**Addendum No. 1**

RE: Contract # C204100

**Guilford County (B-5351)**

Bridges #237 and #242 Over Deep River on US-29/US-70/I-85 Business  
In High Point

PHASE III

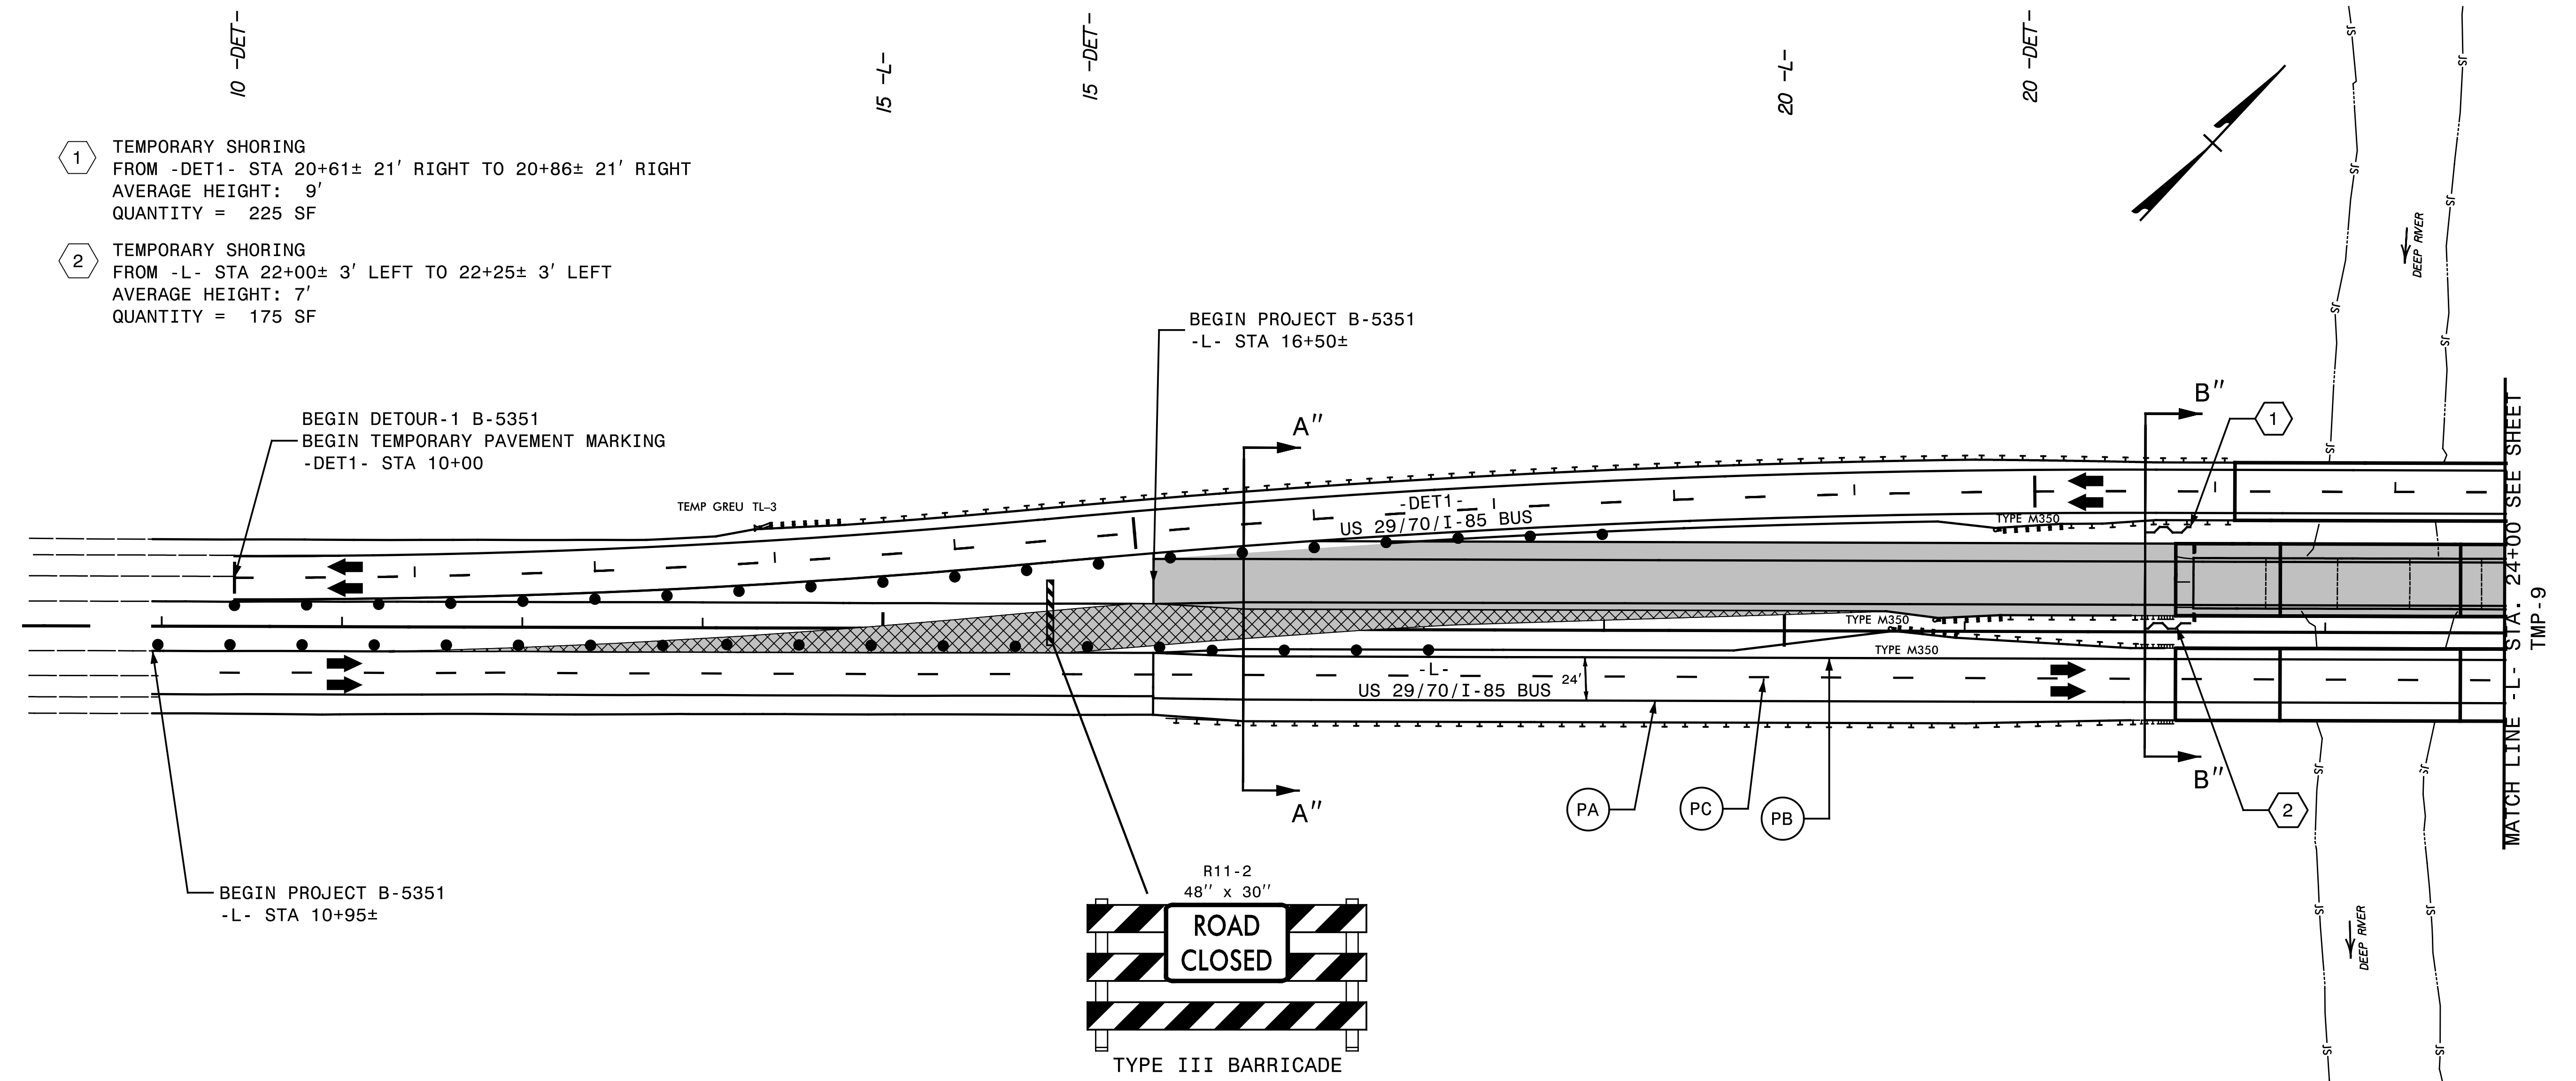
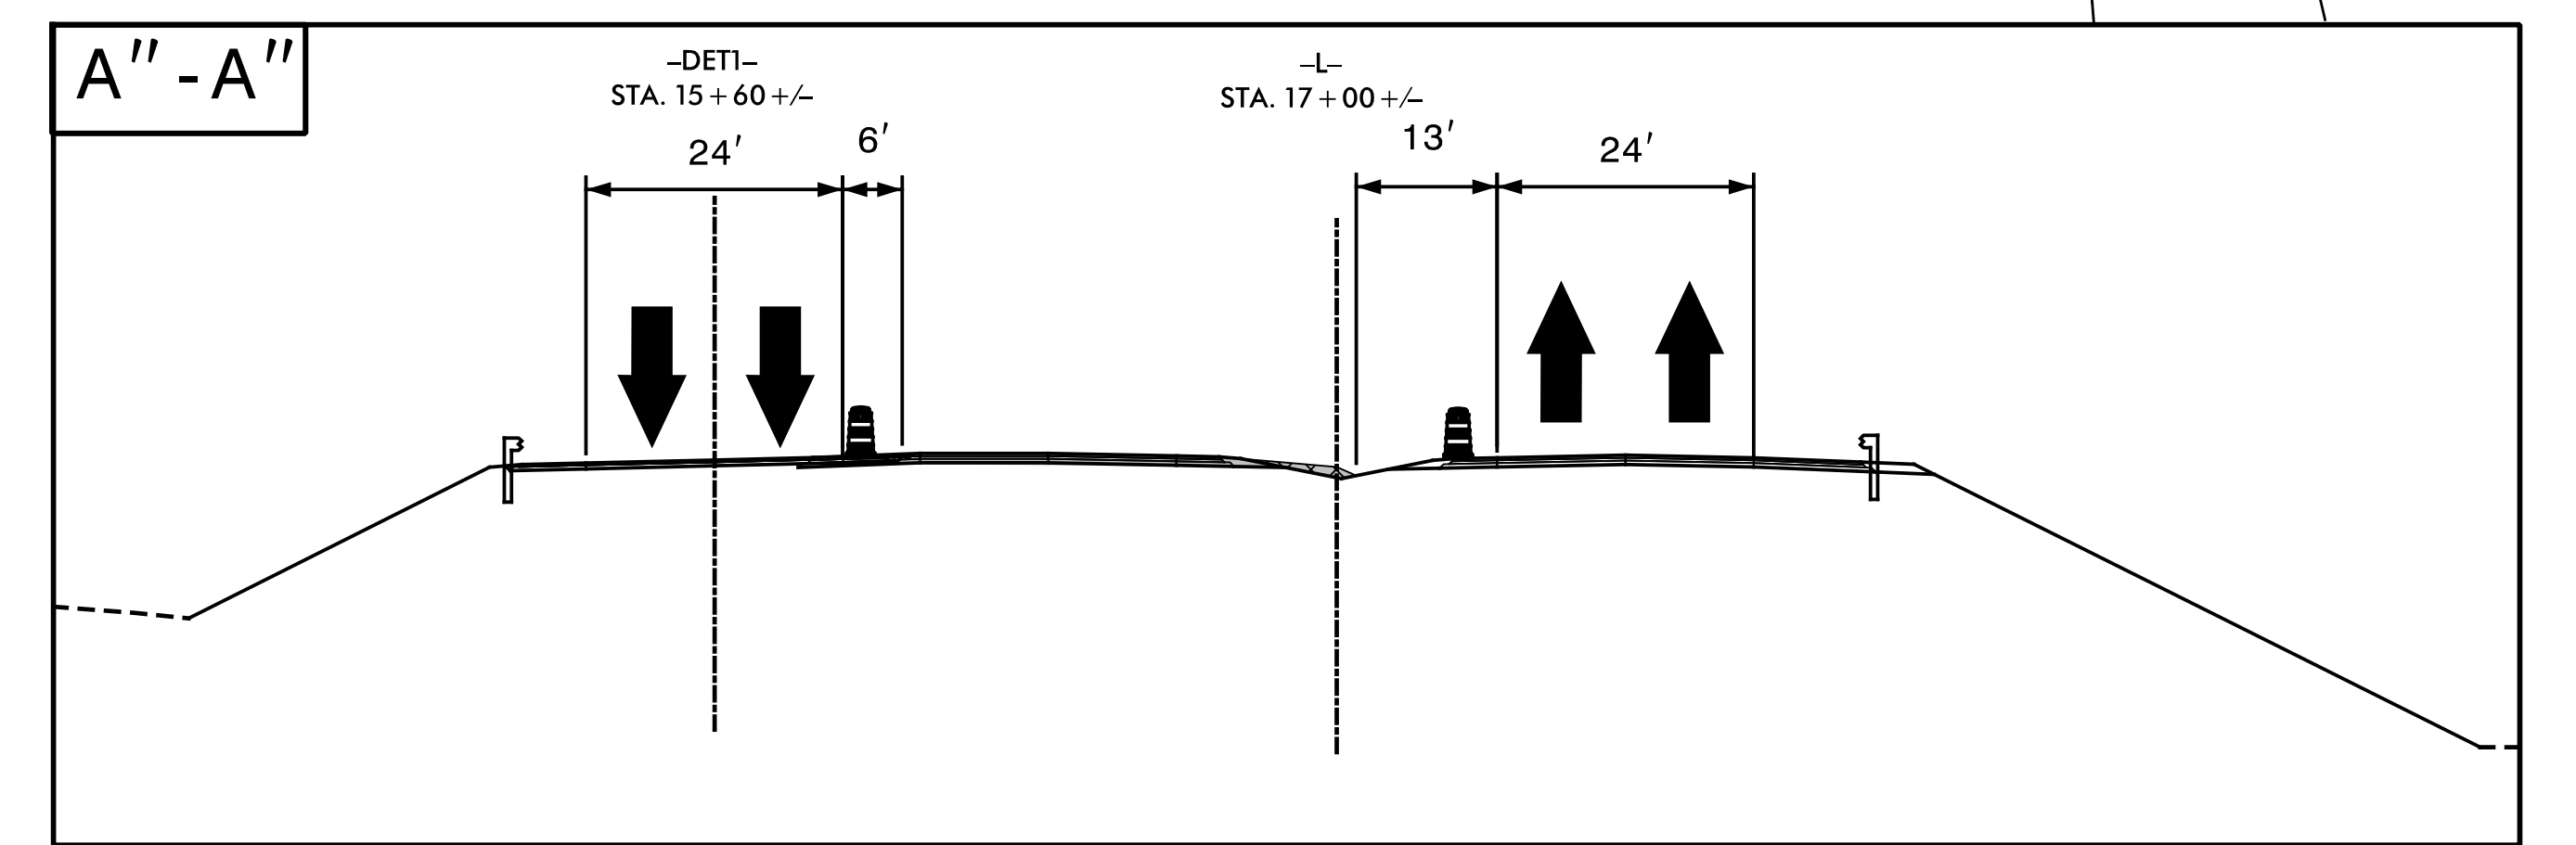
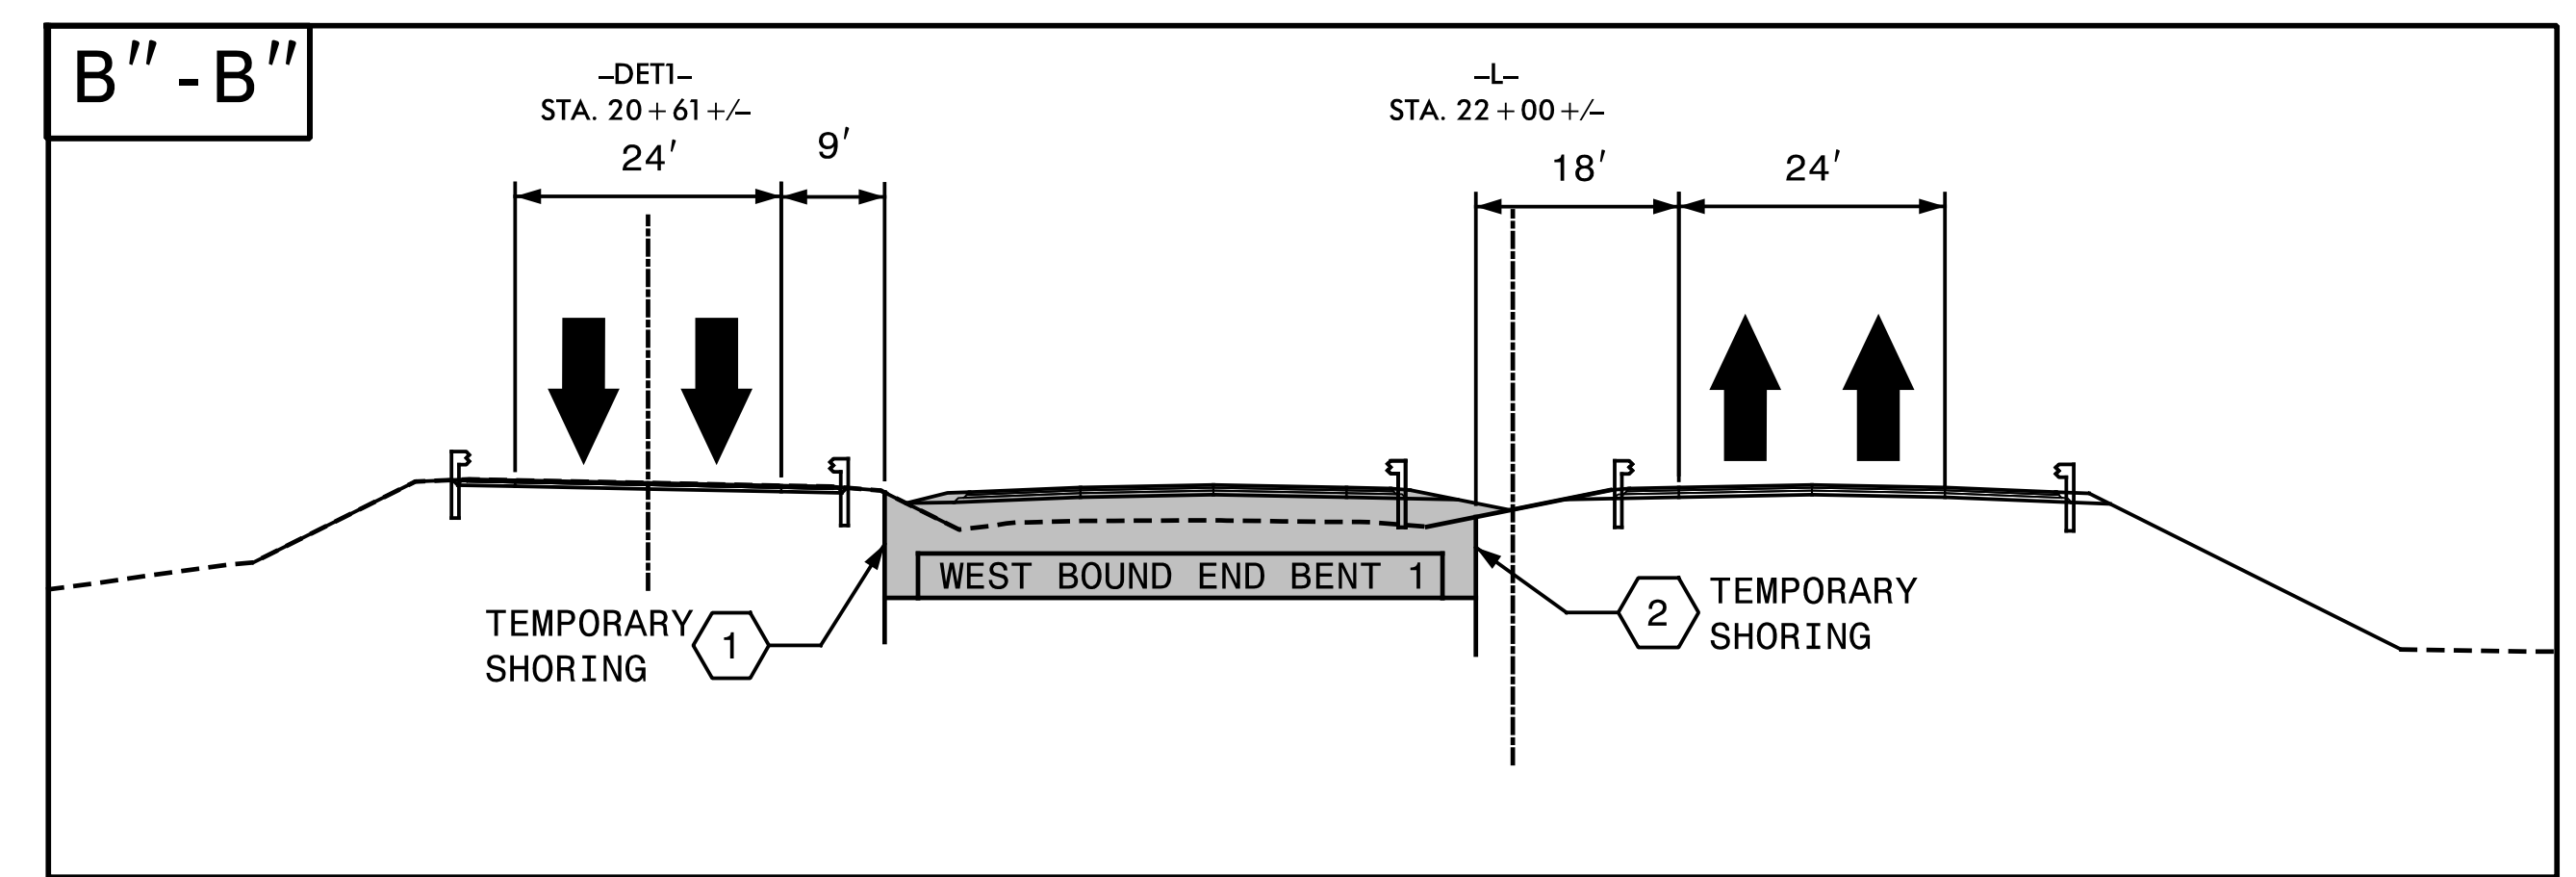
<b><u>Item</u></b>	<b><u>Description</u></b>	<b><u>Old Quantity</u></b>	<b><u>New Quantity</u></b>
013-0199000000-E- SP	Temporary Shoring	870 SF	3,110 SF
189-6048000000-E- SP	Floating Turbidity Curtain	NEW ITEM	360 SY

The Contractor's bid must be based on this revised quantity and include this new pay item.
